**Re: U-Haul at 8200 Jefferson St. NE
Erosion and Sediment Control Plan – C17E146 – (SWQ-2025-00051)
Engineer’s Stamp Date: 2/4/26**

Based on the information in your submittal received on 2/4/26, , the ESC Plan is conditionally acceptable for inclusion in the SWPPP. Additionally, the EPA Notice of Intent (NOI) has been reviewed and signed by the city, and it is attached. Therefore, this project is approved for Building Permit with the following conditions.

EROSION AND SEDIMENT CONTROL PLAN

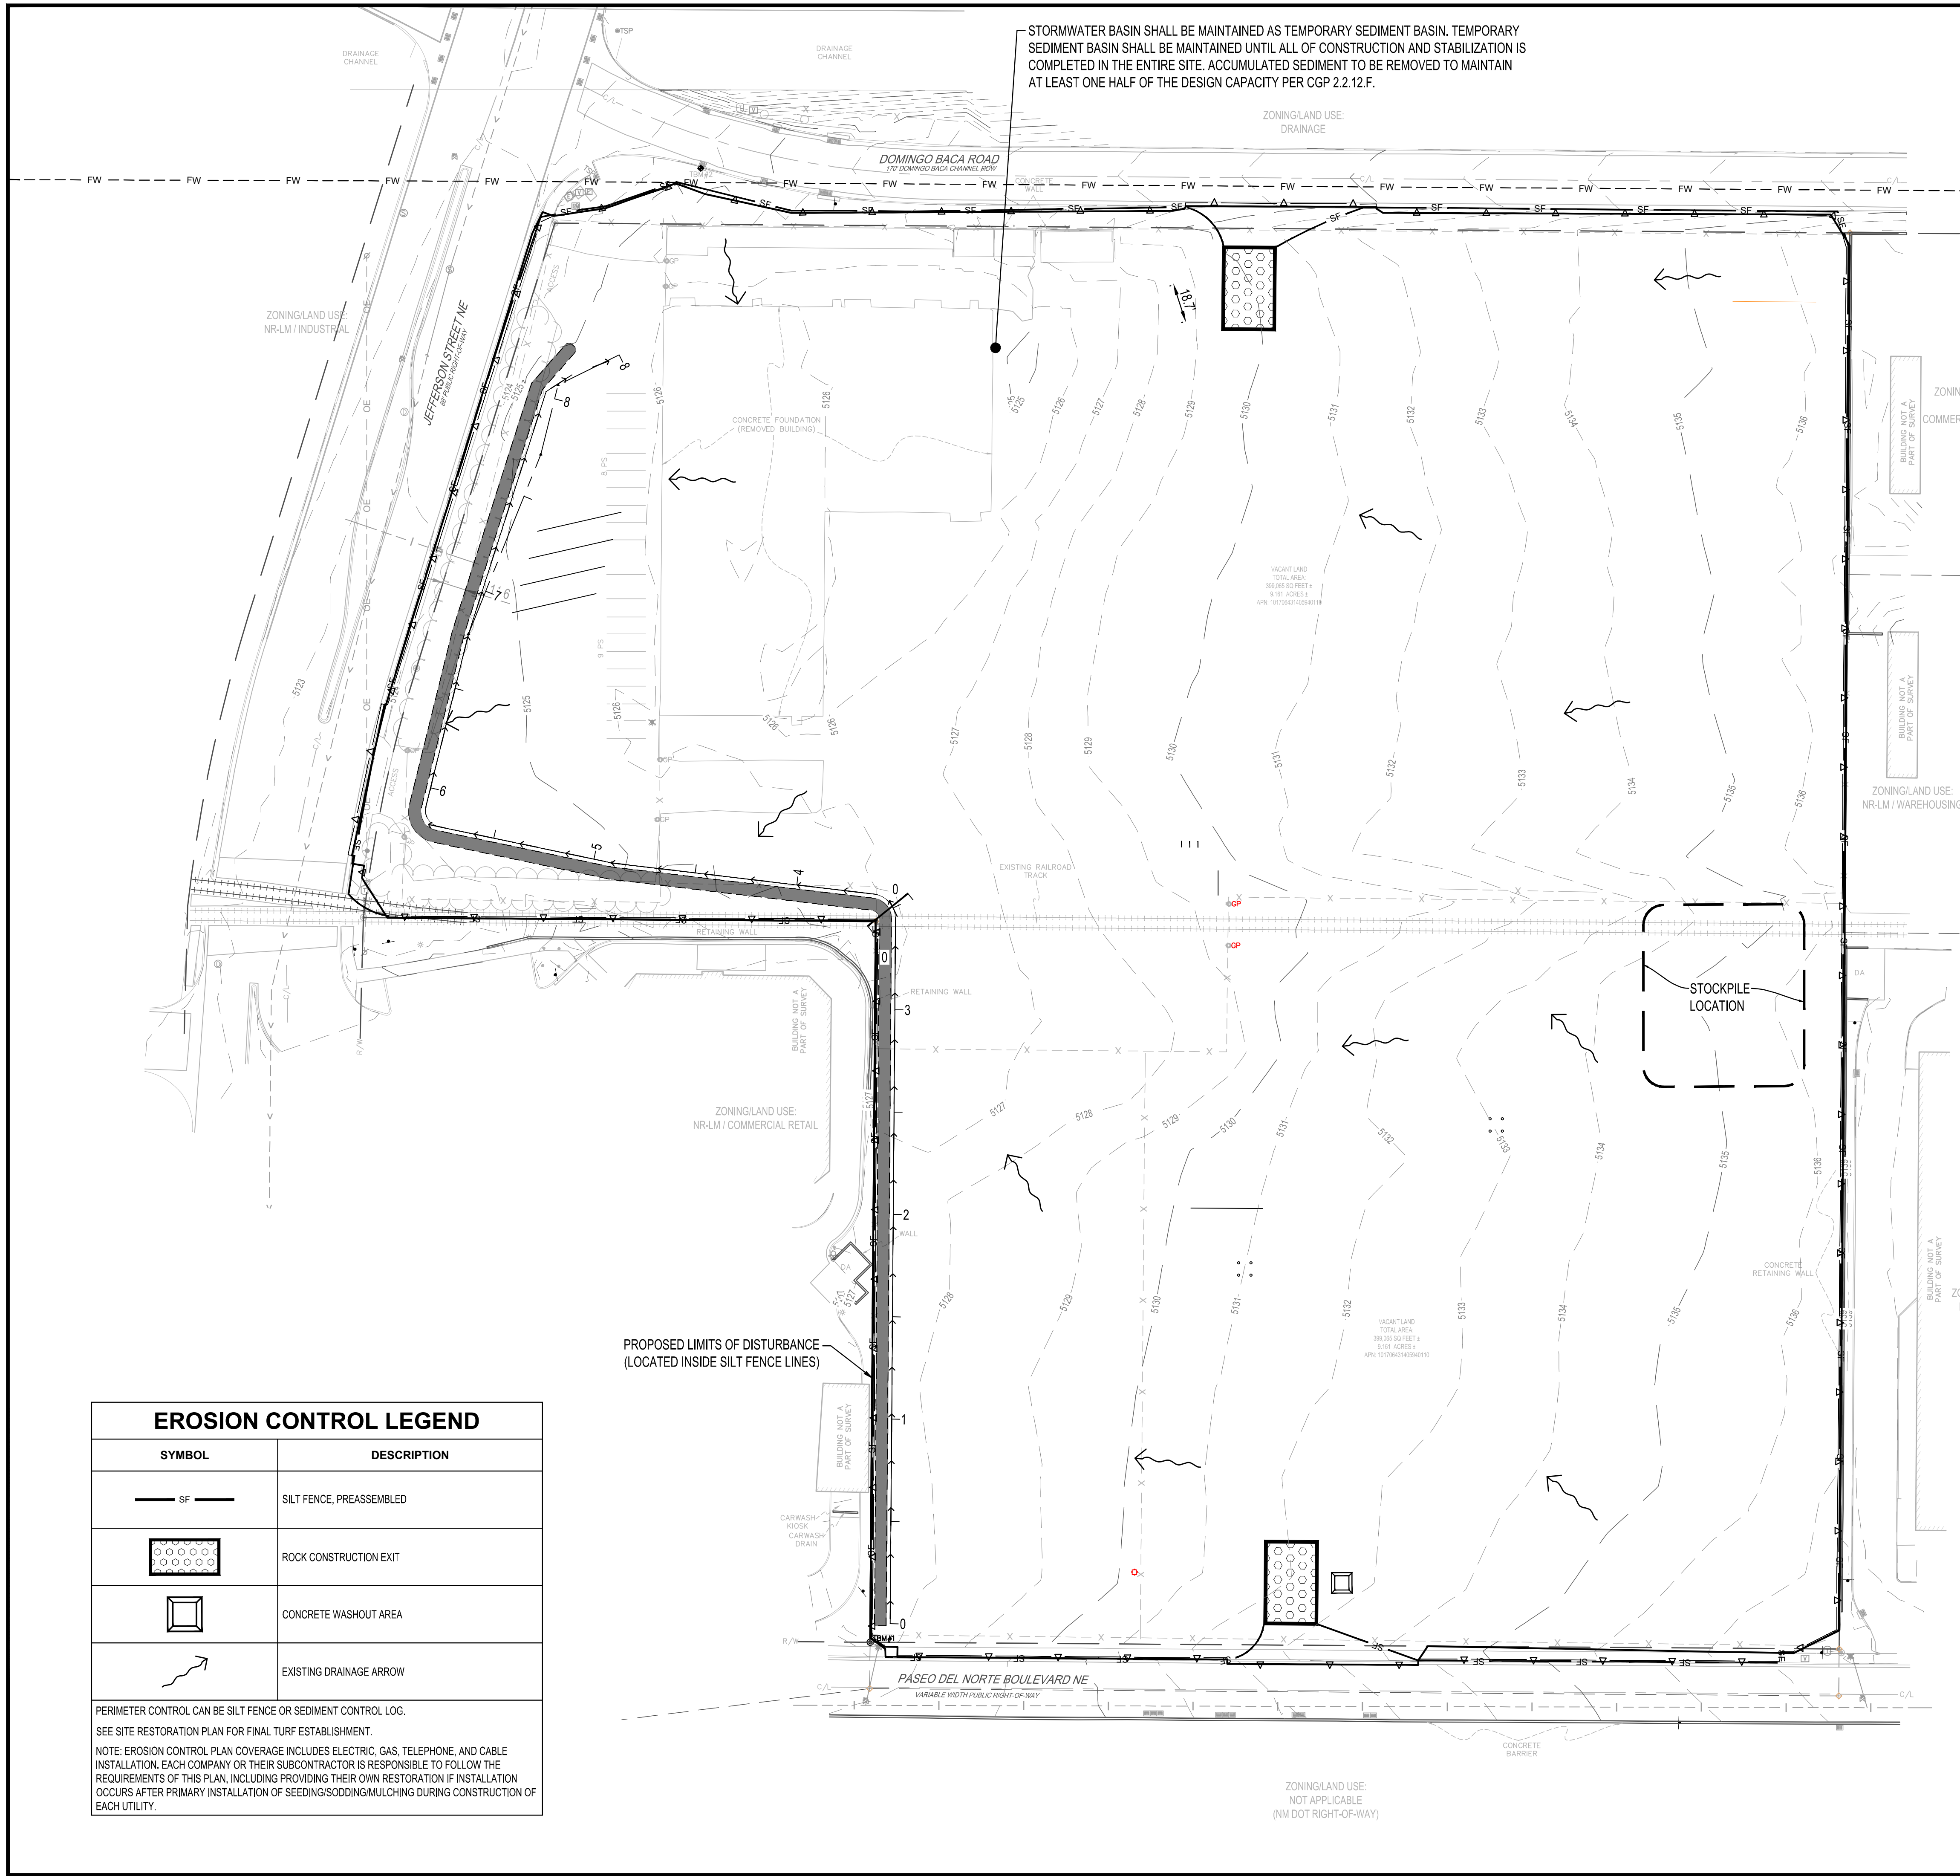
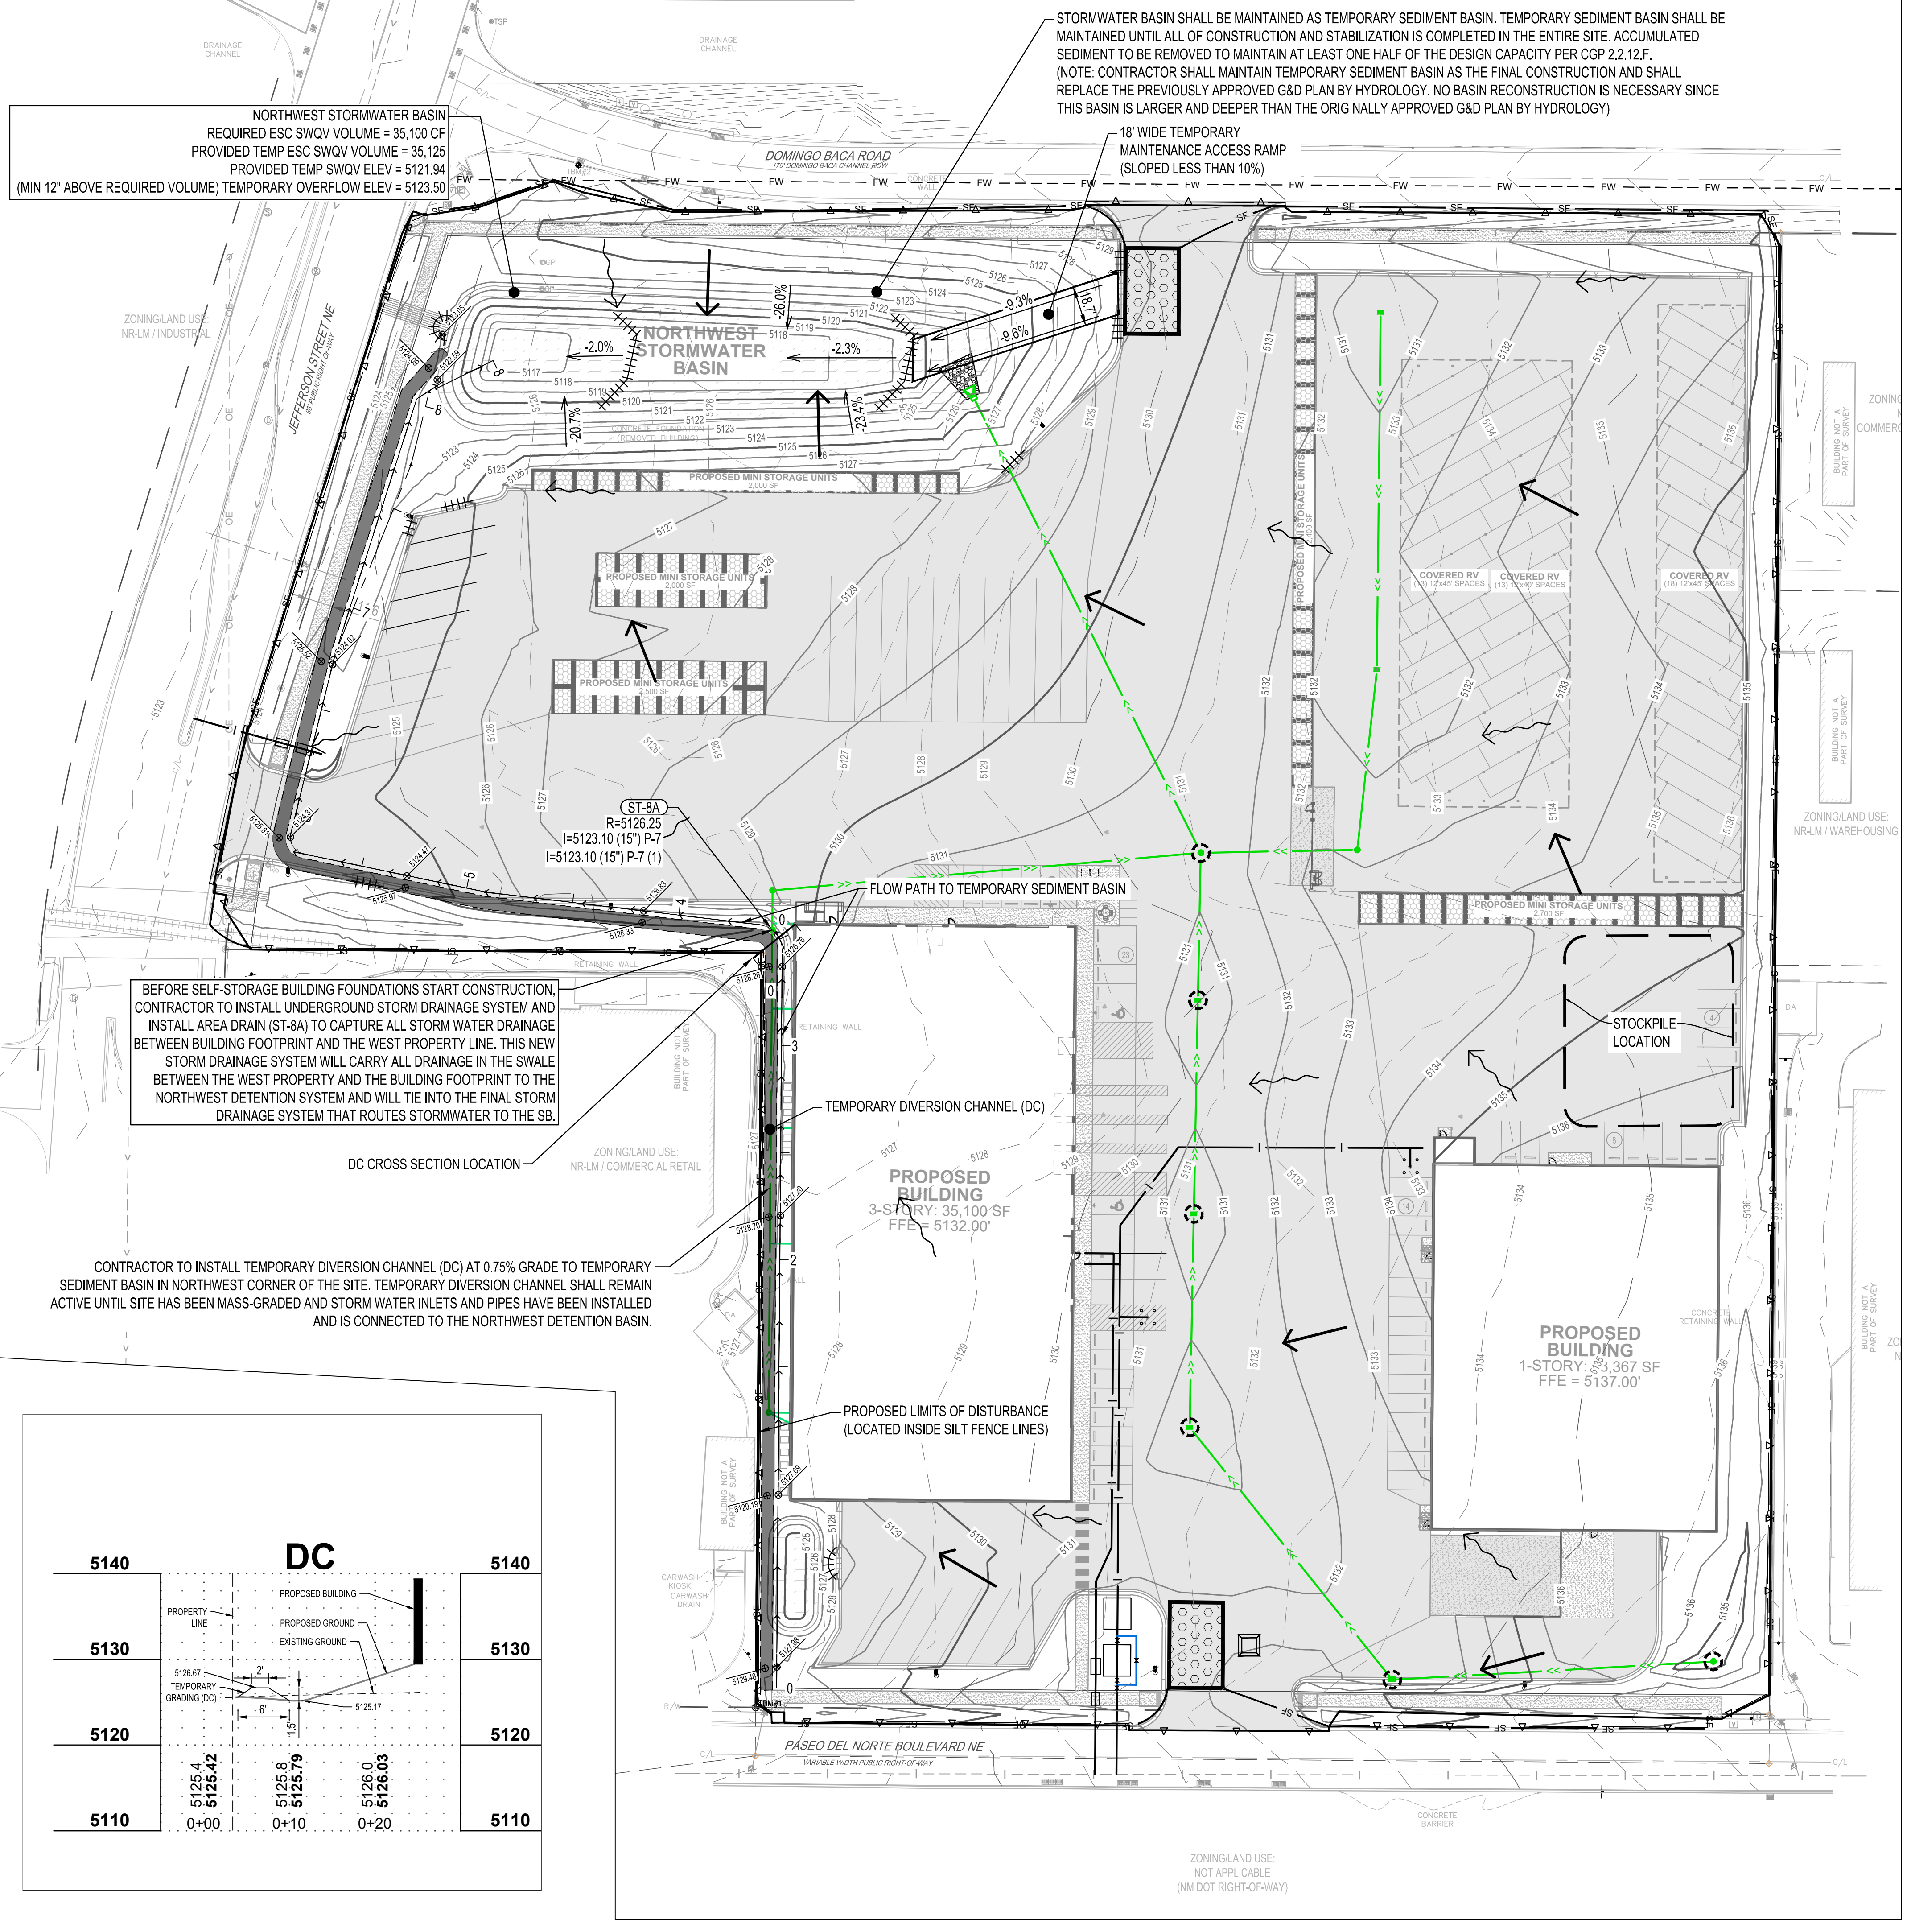
1. Inlets are missing, so the west storm drain cannot replace the DC until a plan showing the inlets is resubmitted to the SWQ Section and approved.
2. SWQ fees for the Work Order have not been paid. Neither Work Order Plans nor IIAs have been submitted to DRC. The pavement items on the infrastructure list aren’t shown on the ESC Plan. Demolition in the Public R/W isn’t allowed without a City Work Order and an NMDOT permit. The work order will not be approved until these items are resolved and an ESC Plan is resubmitted to and approved by the SWQ Section.
